Our ref: 26_34252_P

Your ref: H09-1278-25

Site Location: Land East of Forest Way Holbeach
Spalding Lincolnshire

Summary of Proposal: Proposed Erection
of 2 Bungalows

DRAWING NUMBER : LDC4657 - 10

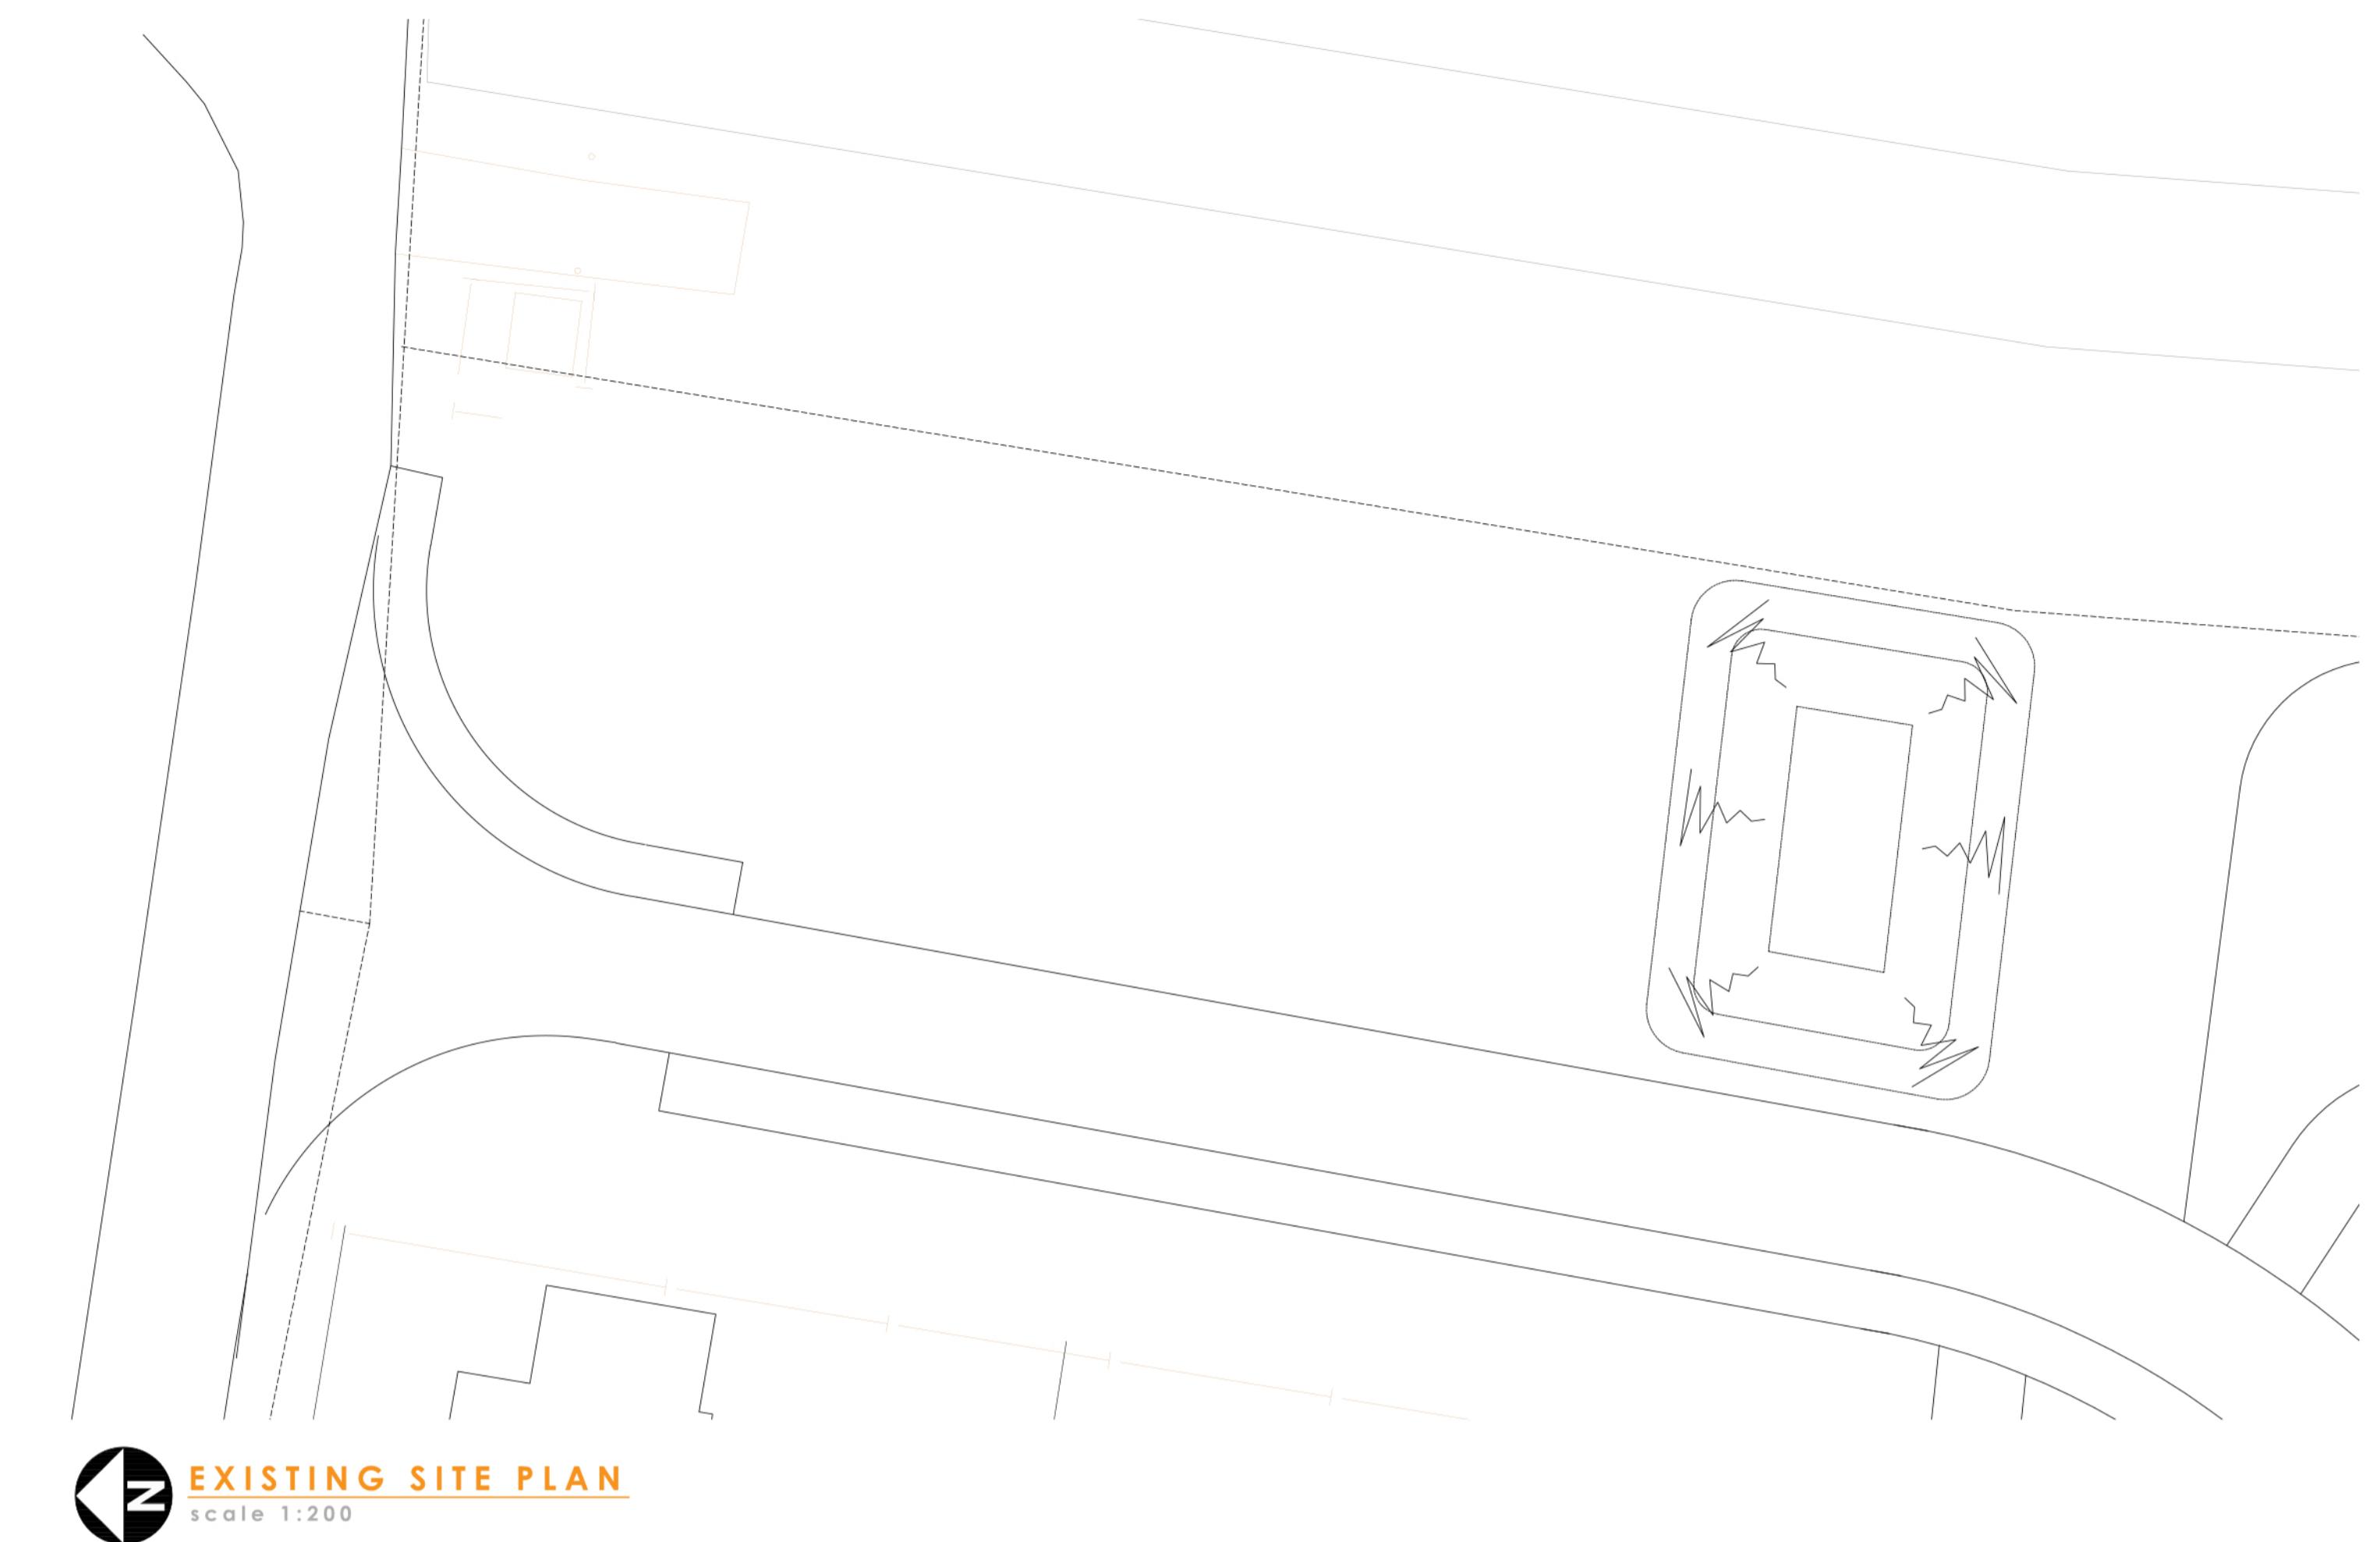
The Proposed Site Plan (LDC4657-10, Dec 2025), indicates the Board's 9 metres Byelaw Zone and works are not currently proposed within this zone. However, if the applicant's proposals change to include works within 9 metres of the aforementioned Board arterial watercourse, or if works within 9 metres of the watercourse are proposed at any time in the future, consent would be required under Byelaw 10. Please note, it is unlikely that the Board would issue consent for any works within this 9 metre Byelaw Zone, now or in the future.
